**KIRKLEES METROPOLITAN COUNCIL  
INVESTMENT & REGENERATION SERVICE**

**DELEGATED DECISION FOR DISCHARGE OF CONDITION -  
NOTIFICATION OF TELECOMMUNICATIONS DEVELOPMENT**

| Reference no.        | <b>2021/N /94296/E</b>                                                                                                                                                               |
| Description          | <b>Prior notification for the<br/>installation of a 16.0m Phase 8<br/>Monopole C/W wrapround Cabinet<br/>at base and associated ancillary<br/>works (within a Conservation Area)</b> |

Title:
260 PROPOSED ELEVATION

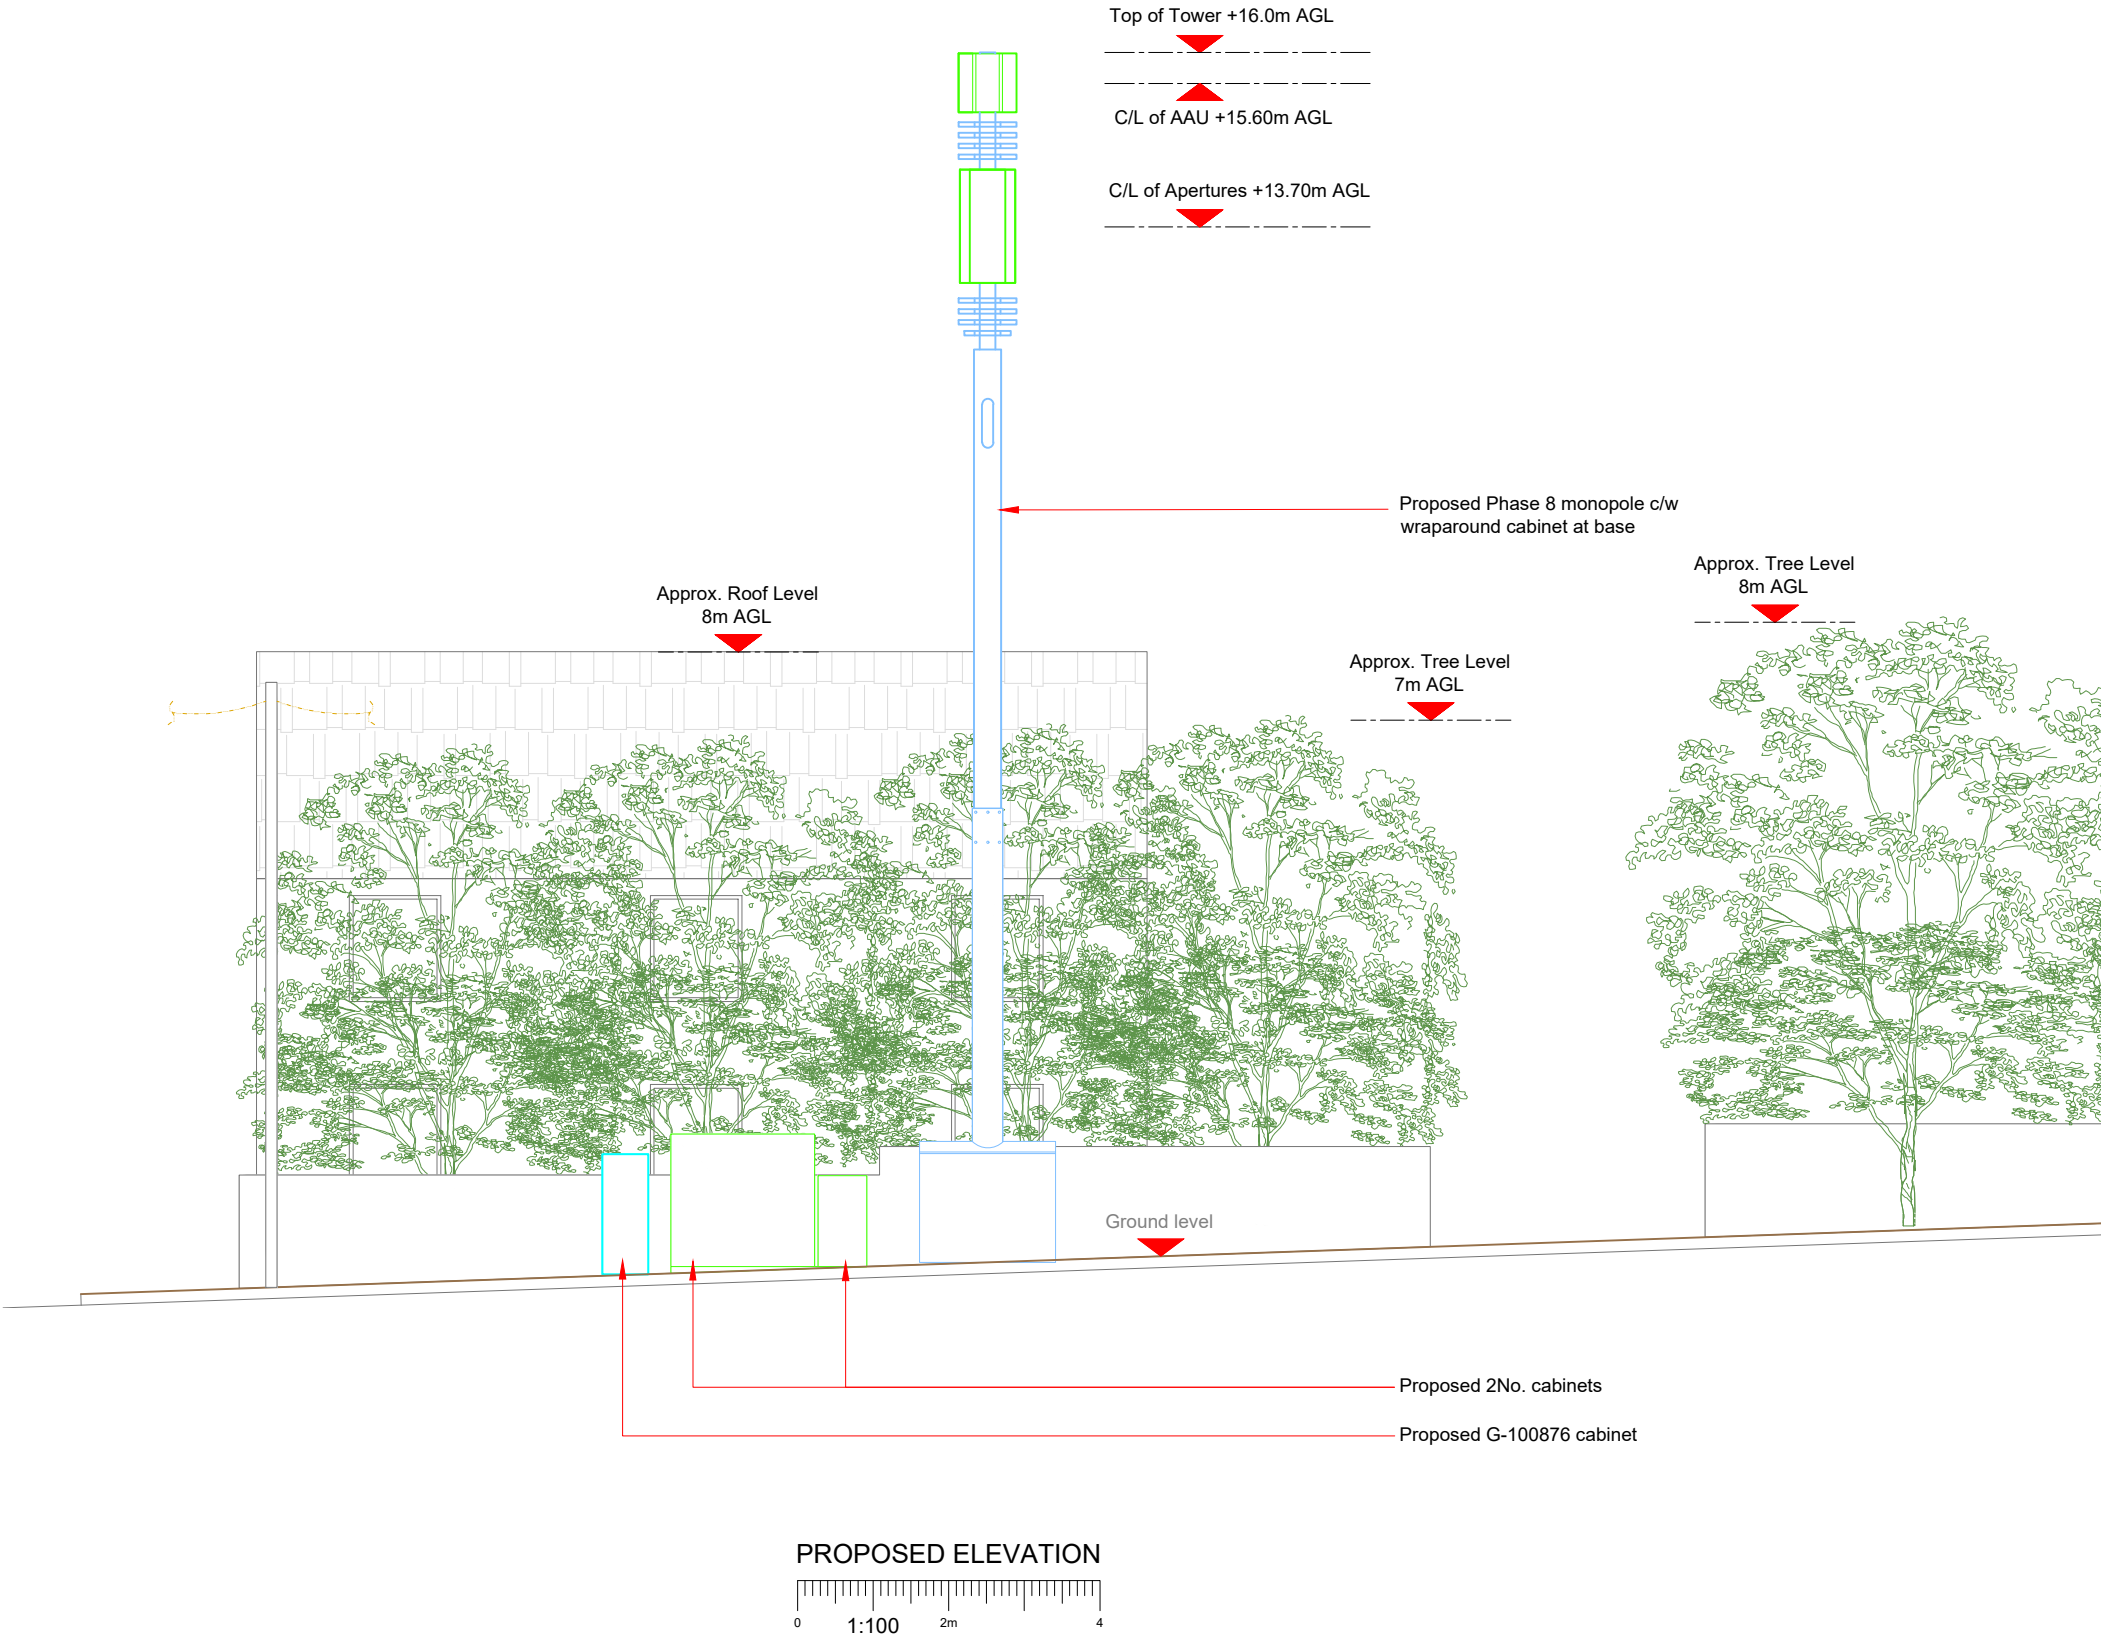
The mast would have an overall height of 16m, to include a single antenna and would be used by a single telecommunications operator. The mast is to have a 'wrap around' cabinet base, measuring 1.8m in overall height, 1.8m in width and 0.8m in depth. The mast excluding the base cabinet would have a diameter of 0.4m.

This viewpoint is reinforced by the appeal decisions APP/Q3305/W/17/3185165 and APP/T0355/W/20/3265640 whereby 15m masts were deemed incongruous given the unsympathetic design, which includes the height. The overall size and poor siting of the mast would mean the development would appear incongruous in this area, which is primarily

residential with low level development. The steel grey colour also would not appear aesthetically pleasing in the street scene. The design can thus not be considered in keeping with the townscape as required by Policy LP24 of the Kirklees Local Plan. Whilst officers note that similar proposals have been considered acceptable in regard to visual amenity within Kirklees, none of these have been set on very prominent, unscreened highway land within such a strongly formed residential areas.

1. The proposed mast, by reason of its siting, size and appearance in regard to form and colour would be a visually intrusive and incongruous feature in the streetscape appearing wholly out of scale with the surrounding residential properties and failing to respect the character of the area. The siting, size and appearance would also fail to conserve or respect the character of the Shepley Conservation Area setting as required by Local Plan policy. The proposed development would therefore be contrary to Policies LP24 and LP35 of the Kirklees Local Plan and Chapters 12 and 16 of the National Planning policy Framework.

2. The proposed mast, by reason of its siting, size and appearance would not ensure a good standard of amenity for neighbouring occupiers. The siting of a 16m mast in such a close proximity to the principal elevation of dwellings would appear overbearing and cause undue harm. To permit the development would be contrary to Local Plan policy LP24 with regard to the impact on the residential amenity of neighbouring occupiers.
